MVEA YODER SUBSTATION

EL PASO COUNTY

SITE PLAN

APRIL 2018

MVEA YODER SUBSTATION
SITE PLAN

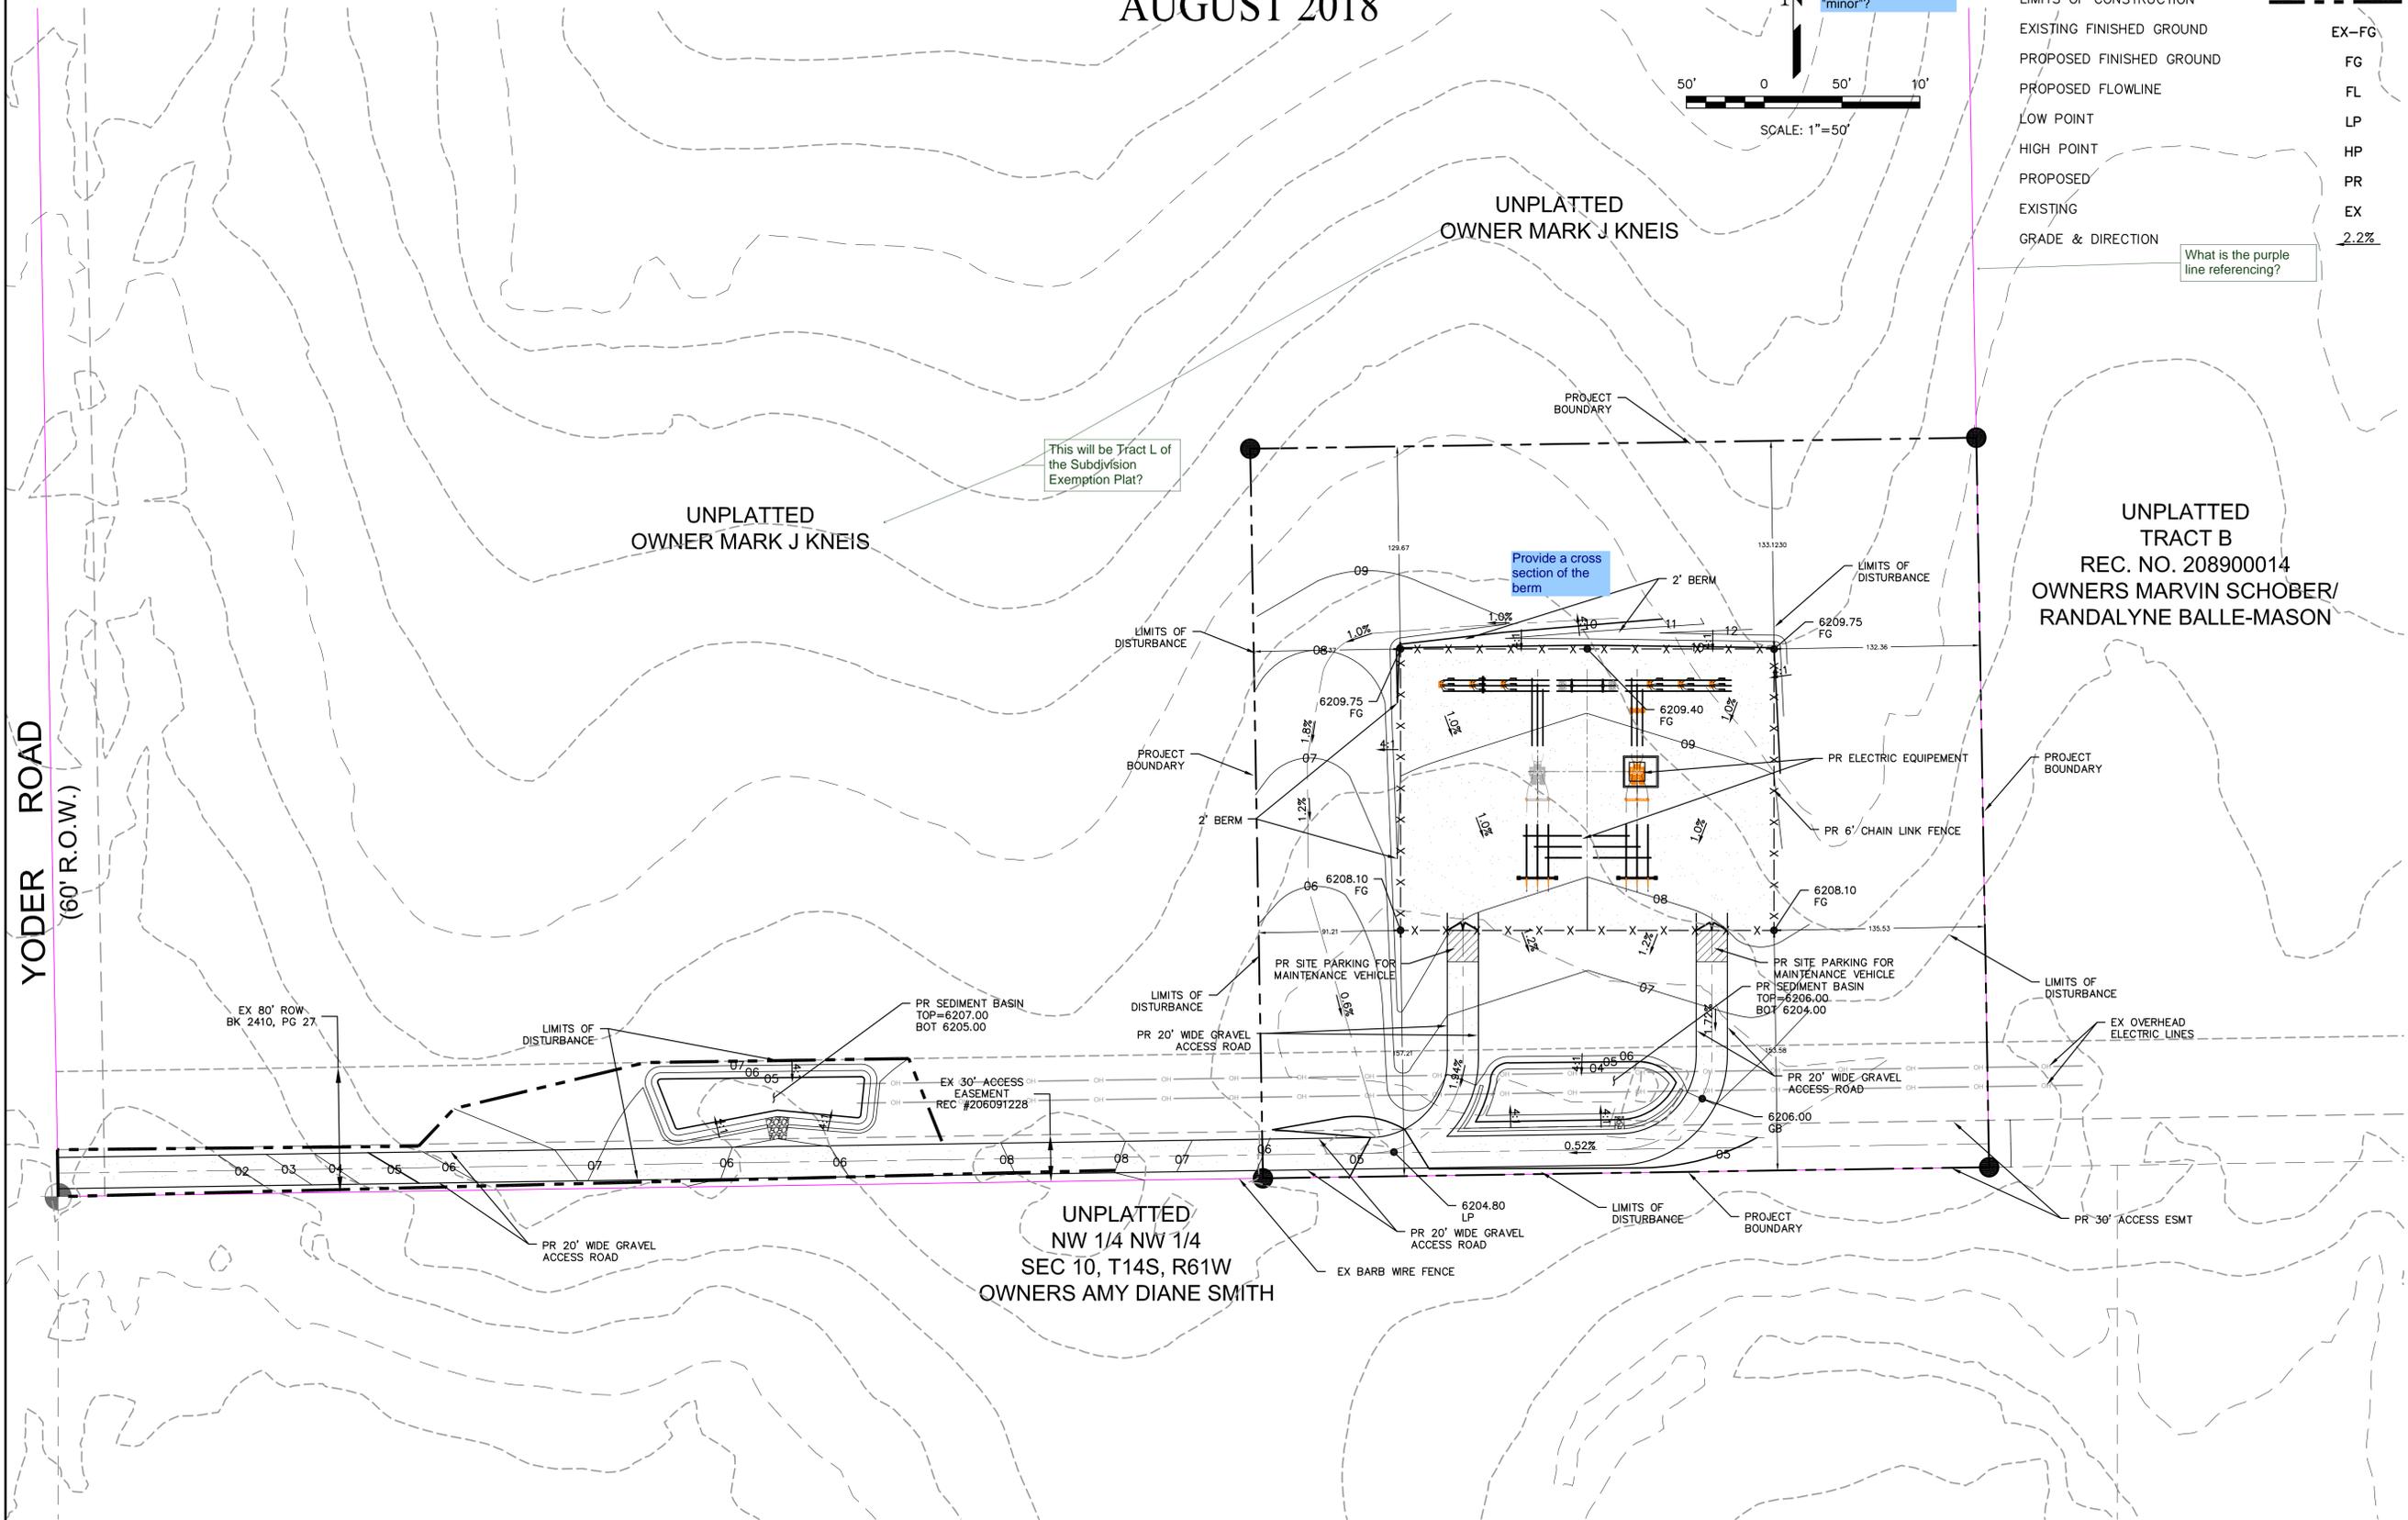
please show hatch for all proposed gravel and concrete surfaces.
 please show the access road in its entirety.
 Please show cross section of the fence and berm.

please show all existing fences on the southerly property line.
